**KIRKLEES METROPOLITAN COUNCIL
INVESTMENT & REGENERATION SERVICE**

DELEGATED DECISION TO DETERMINE PLANNING APPLICATIONS

Reference No: 2019/62/93605/E

Site Address: April Court, Roberttown, Liversedge, WF15 7RB

LEVEL DATUM
GRID DATUM
DATUM USED
GPS
GPS : ST01
Value 121.170m
DRAWING NO. 8057/1

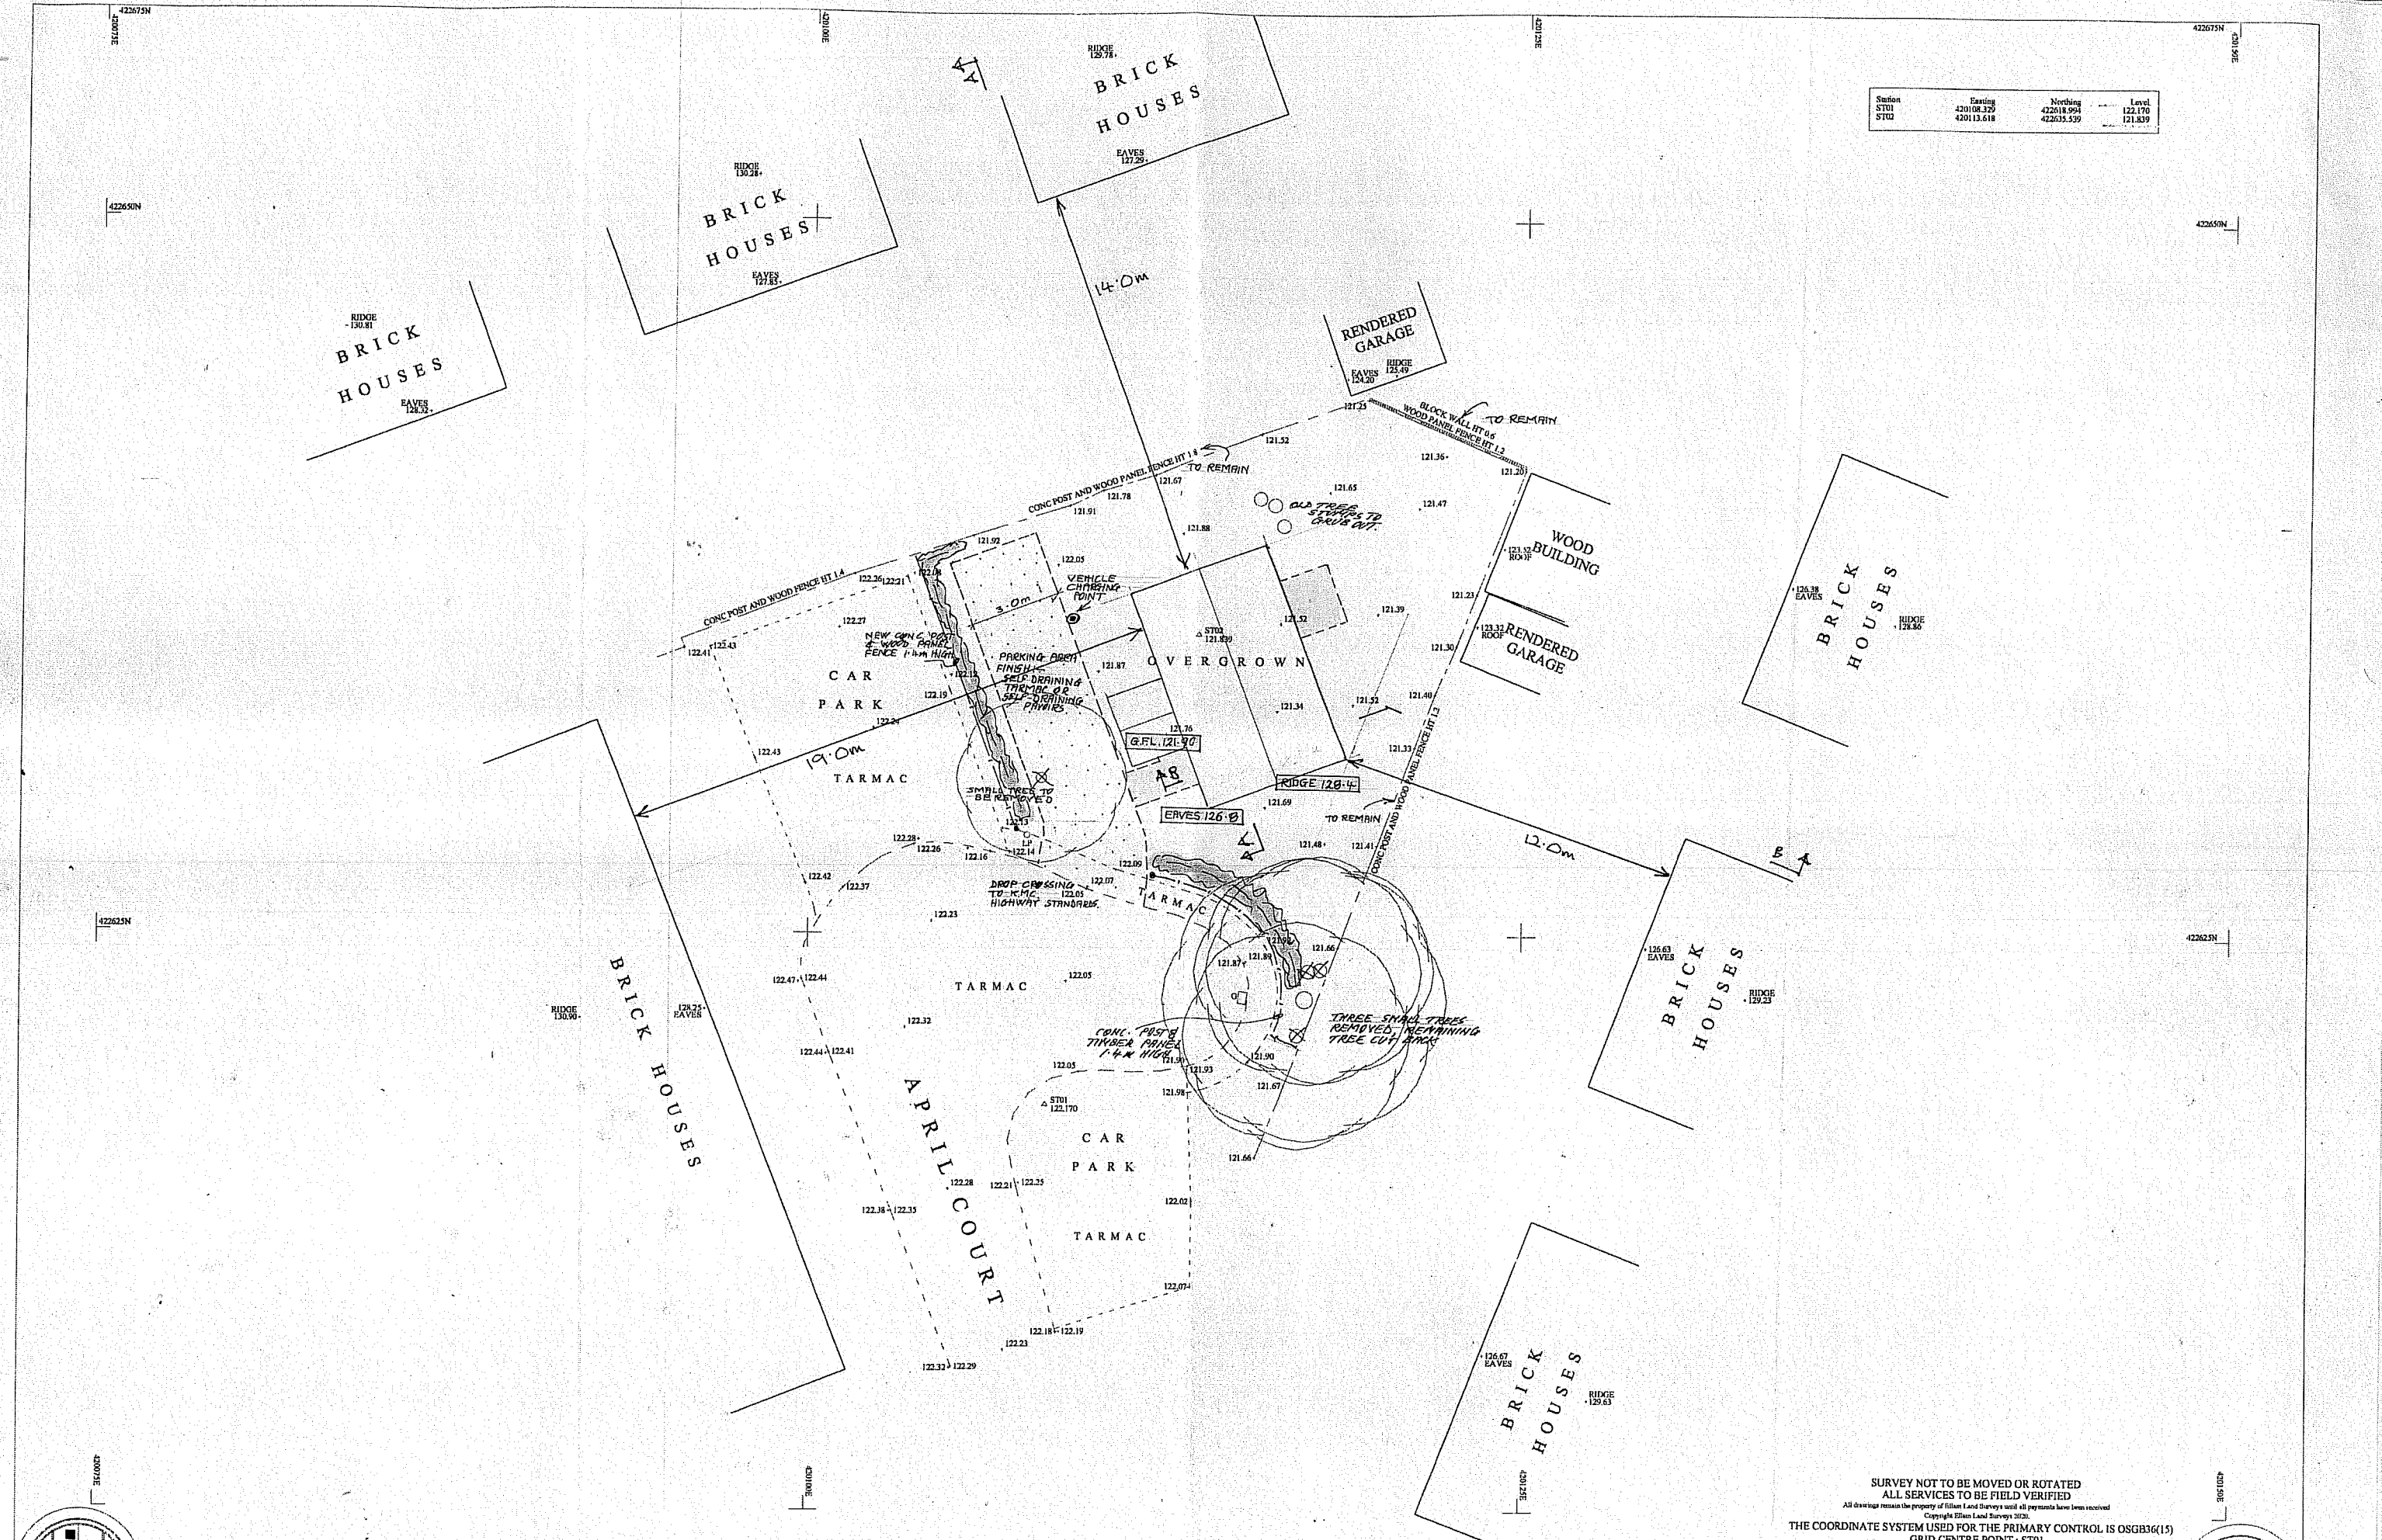
The agent's block plan shows the relationship between the proposed dwelling and this row of terraced properties. There is a distance of 19 metres between habitable-room windows and, therefore, consideration has been given to whether this distance is sufficient to ensure an acceptable level of amenity for the existing occupiers.

In terms of parking provision, the plan shows two parking spaces for the dwelling which is acceptable to ensure that the displacement of vehicles will not occur on the highway, and the existing parking provision for residents will not be altered. It is also noted that there is scope within the application site to provide bin storage and collection, and, therefore, this aspect can be dealt with the inclusion of a suitable condition.

4. The development shall not be brought into use until all areas indicated to be used for paving on the submitted site plan have been marked and laid out with a hardened and drained surface in accordance with the Communities and Local Government; and Environment Agency's 'Guidance on the permeable surfacing of front gardens (parking areas)' published 13th May 2009 (ISBN 9781409804864) as amended or any successor guidance. Notwithstanding the provisions of the Town and Country Planning (General Permitted Development) Order 2015 as amended (or any Order revoking or re-enacting that Order) these areas shall be so retained, free of obstructions and available for the use(s) specified on the site plan (ref. 33NL04).

SECTIONS

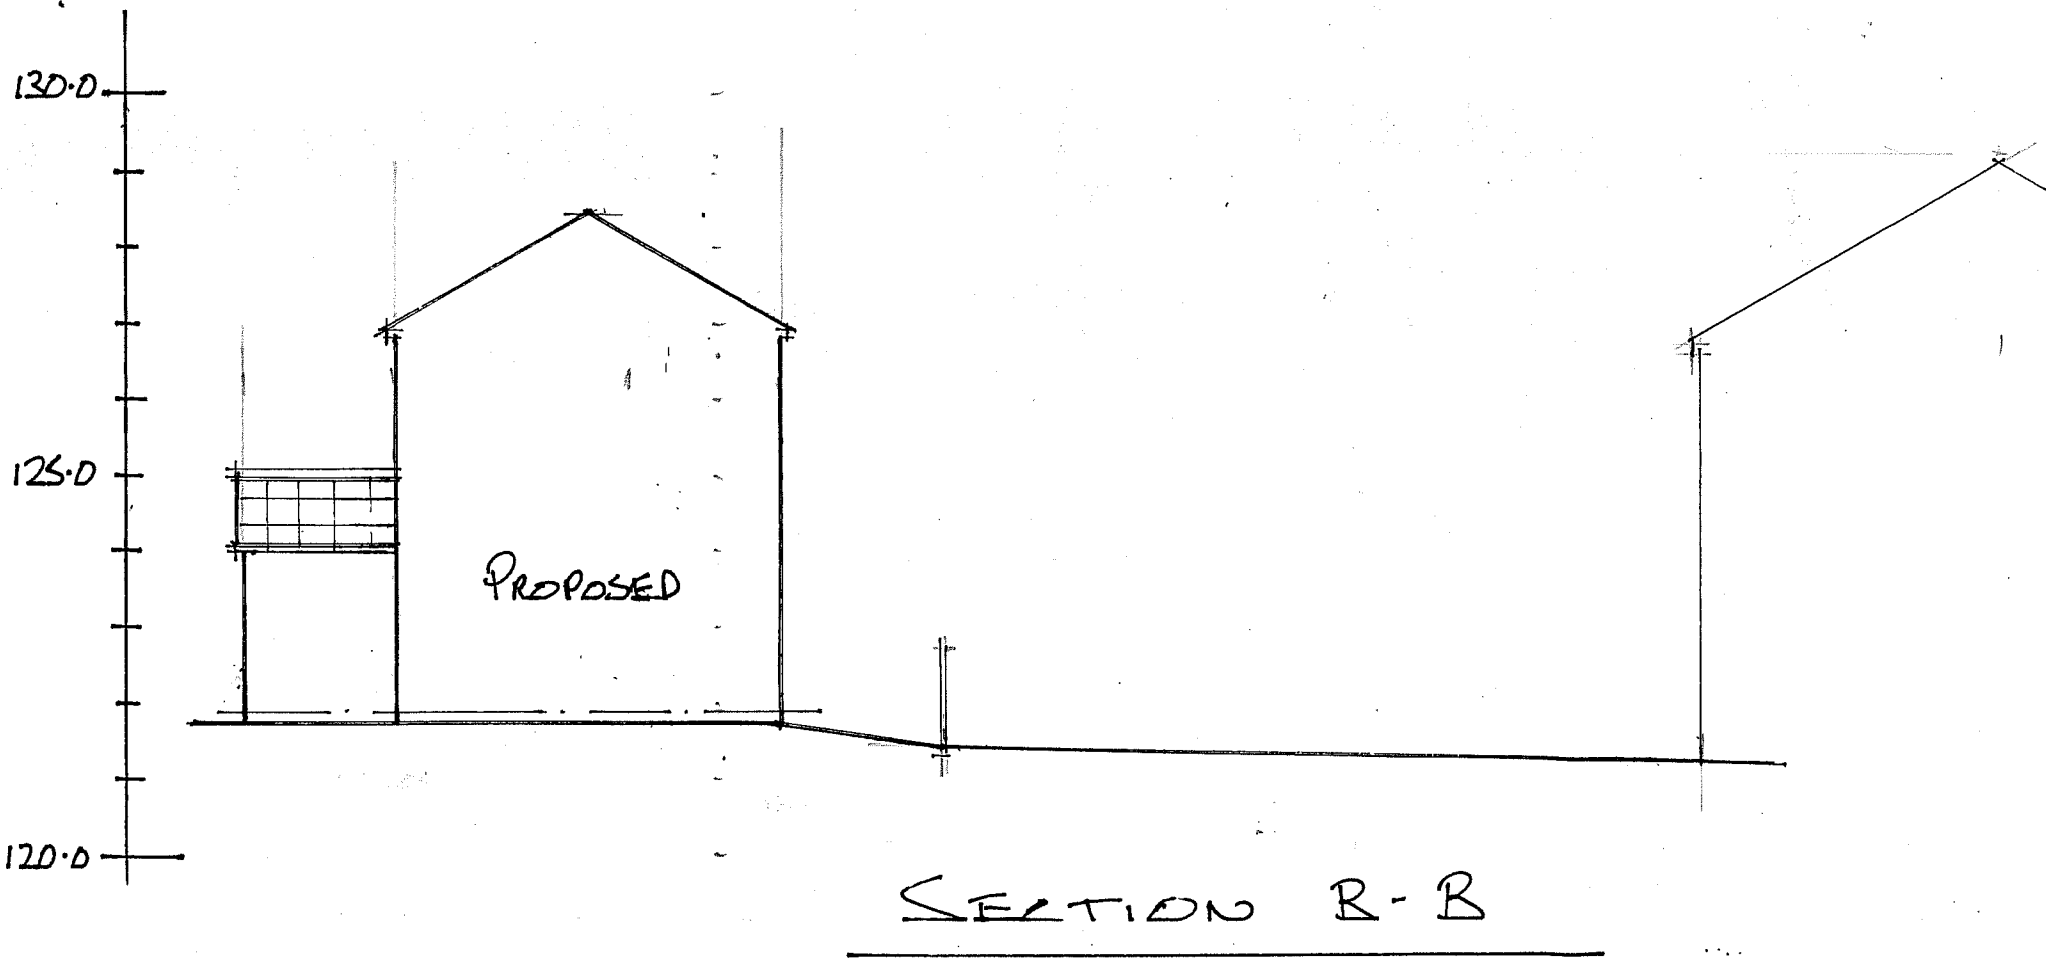
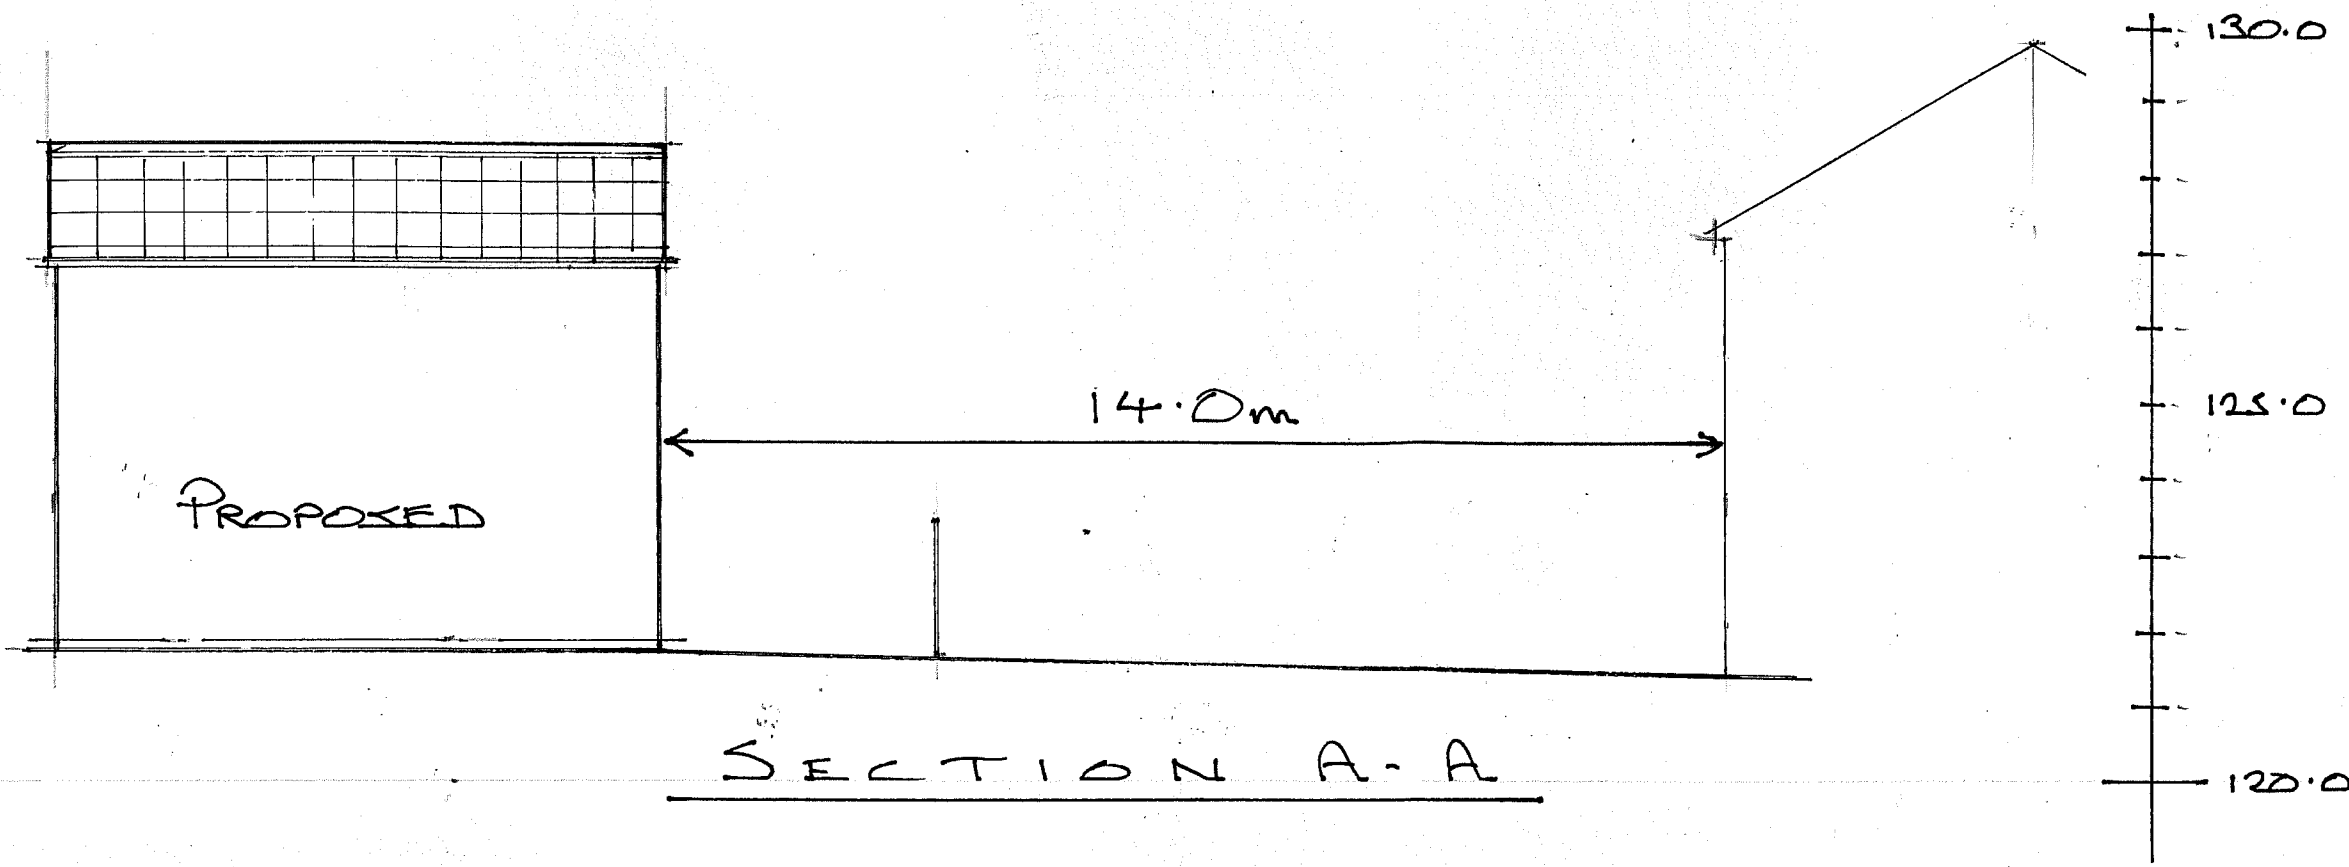
The applicant has provided a section drawing which demonstrates the relationship between the proposed dwelling and those on Lumb Lane, which sit on a slightly lower level and have habitable-room windows in their side elevations. The section plan shows a distance of 14 metres between the side elevation of the proposed dwelling and the rear elevation of the neighbouring property. The plan also shows that the proposed dwelling would have a lower eaves and ridge height than the closest neighbouring dwelling on Lumb Lane. It is considered that the section plan shows that, on balance, the relationship between the properties would be acceptable and would not result in a significant overbearing or overshadowing impact, sufficient to warrant refusal of the planning application.

The agent has also provided a section drawing to demonstrate the relationship between properties on Huddersfield Road and the application site. This section plan shows the neighbouring dwellings on a lower level. These dwellings have habitable-room windows in their rear elevations and, therefore, careful consideration has been given to the relationship between the properties.

The distance of 12 metres between the rear elevation of both the neighbouring property and the application property is considered, on balance, to be acceptable. As can be seen from the block plan, the dwelling does not have a direct relationship with any of the properties fronting onto Huddersfield Road, thus the potential impact of the additional bulk and massing is reduced to an acceptable level. Given this relationship, and the fact that the scale of the proposed dwelling is not inappropriate for the site (the eaves height is the same as the neighbouring property, and the dwelling sits lower than the ridge), any overbearing impact would not be sufficiently harmful to constitute a valid reason for refusal.
